Cornwall Design Review Panel Meeting: Wednesday 6th June 2018

Site Address: Polvellan Manor, Looe

Proposal: Demolition and works to existing house to form apartments, with new residential development in several locations within the grounds, landscape, etc.

Panel Guidance

Existing elevations with area of demolition shown in red

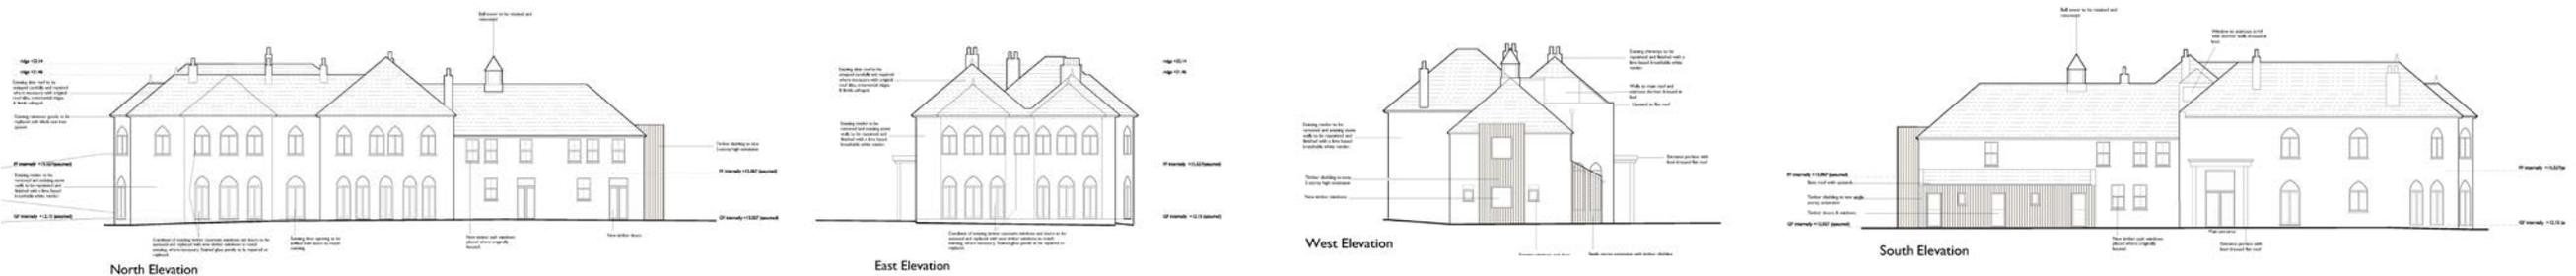
The re-modelling of the house to remove later extensions seems sympathetic to the original building. The contrast formed between the existing building and the proposed new linked units is positive to both and the fragmentation further helps this distinction by drawing the new additions back into the landscape. Further spatial separation of the Manor from the linked units will help the Manor to read as a separate building and the new accommodation is not seen to grow out of it - this will lend better integrity to both.

Turning back to the original house we were not clear on whether a coherent strategy had yet been evolved to deal with the rear elevation – which will need extensive repair / re-modelling following demolitions?

Initial Mews Proposal

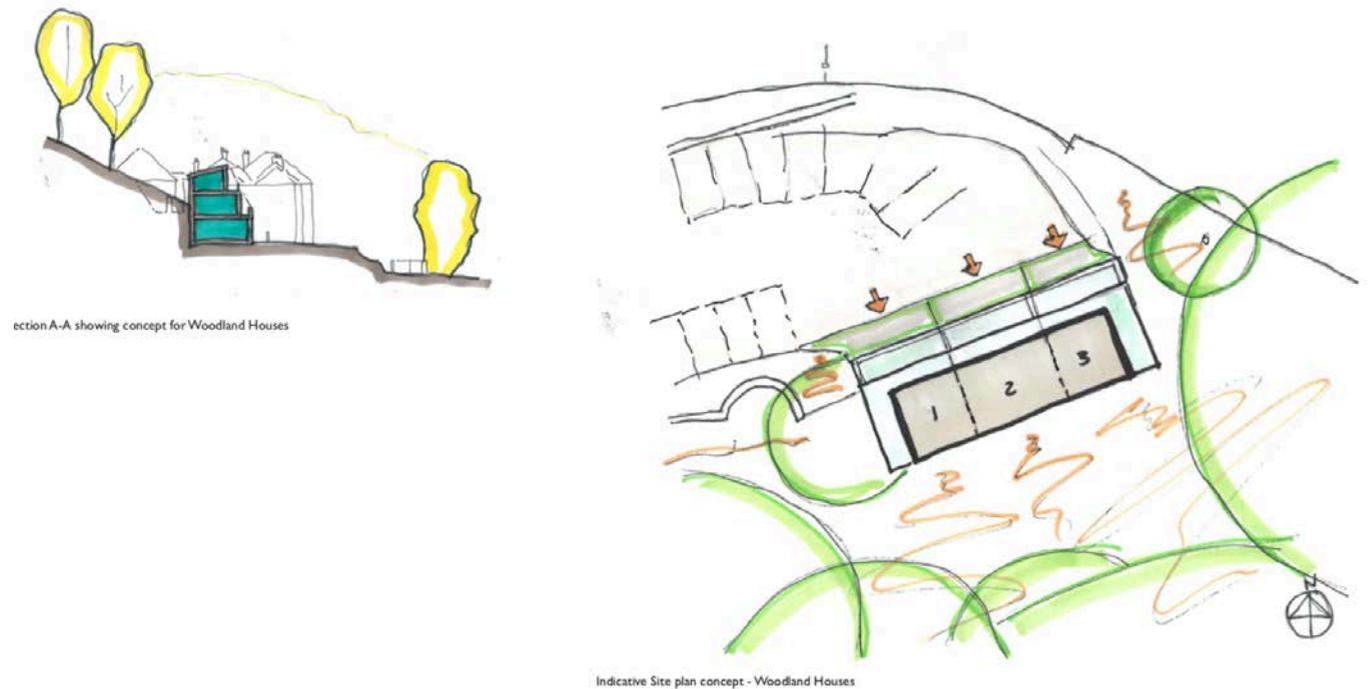
Beginning with the least satisfactory of these (in terms of detail), we find the 'Mews' element at the eastern end of the site to be an awkward replacement for the cylindrical apartments that were previously proposed. We feel this element is mis-named, this is not a mews condition and the short-terraced form fails to set up a coherent relationship back to the important east front of the main house. We are also concerned that the proposals do not pay sufficient respect to the 'lookout' landscape feature which exists nearby and the basic proposition of development in this location needs to be more sensitively considered. Given the emerging architectural language of the rest of the site

We are encouraged by the breaking up of the proposals into smaller development components sitting as a series of interconnected buildings – this ought to allow a closer adherence to subtle topographical characteristics. Perhaps the 'Mews' component should also adopt this same typology (see our earlier question above?).
